CITY OF ALBUQUERQUE

August 12, 2024

Re: VCA Vet Care Hospital
8850 Holly Ave. NE
30-Day Temporary Certificate of Occupancy
Transportation Development Final Inspection
Architect's Stamp dated 09-20-21 (C20-D071)
Certification dated 08-09-24

SHEET  
TCL-001

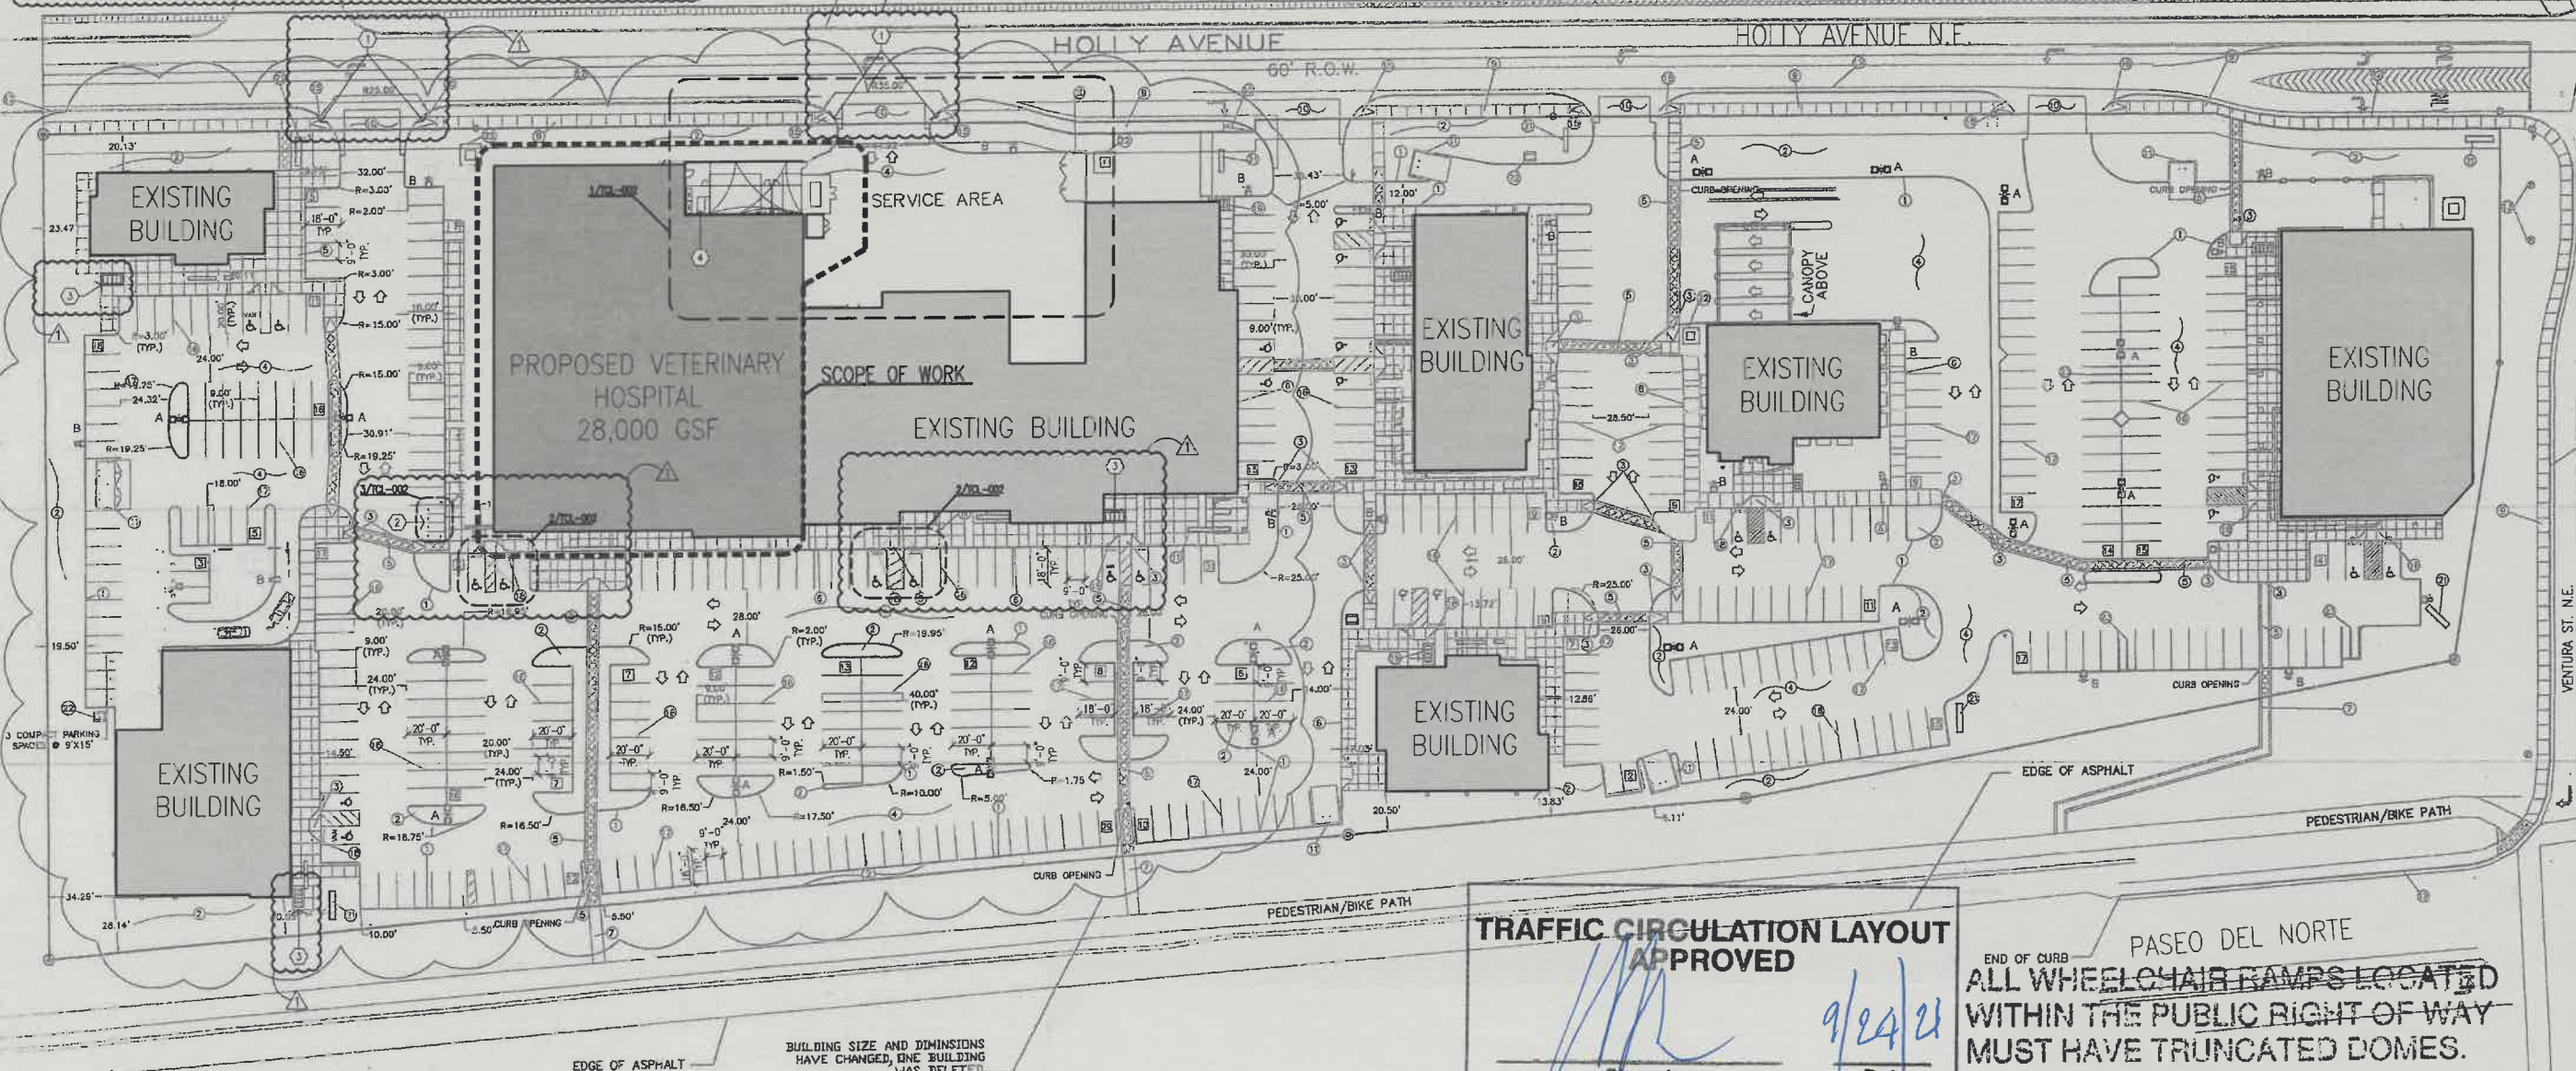
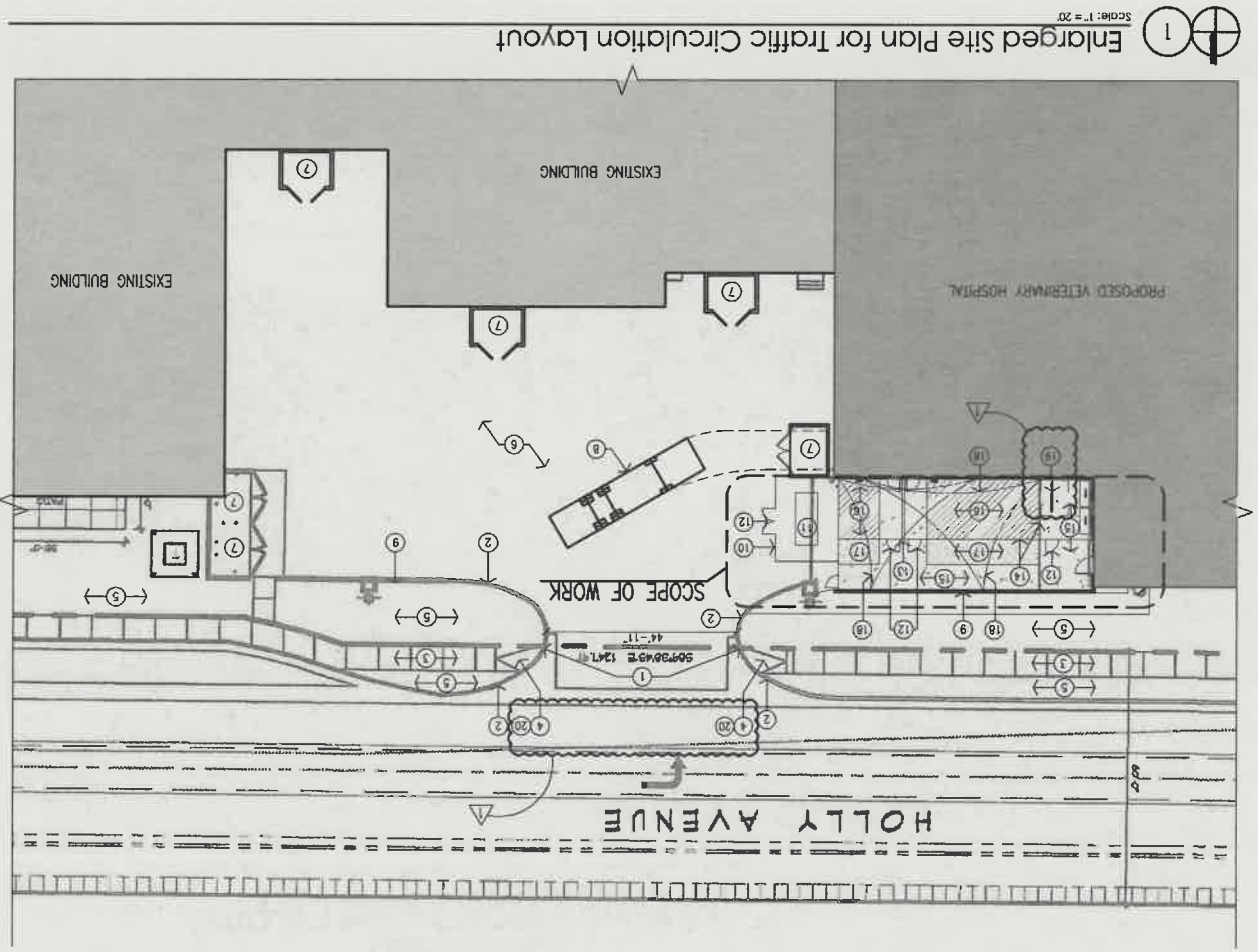
- The ADA accessible parking sign must have the required language per 66-7-352.4C NMSA 1978 **"Violators Are Subject to a Fine and/or Towing."** Please call out detail and location of signs.
- The ADA access aisles shall have the words **"NO PARKING"** in capital letters, each of which shall be at least one foot high and at least two inches wide, placed at the rear of the parking space so as to be close to where an adjacent vehicle's rear tire would be placed. (66-1-4.1.B NMSA 1978)
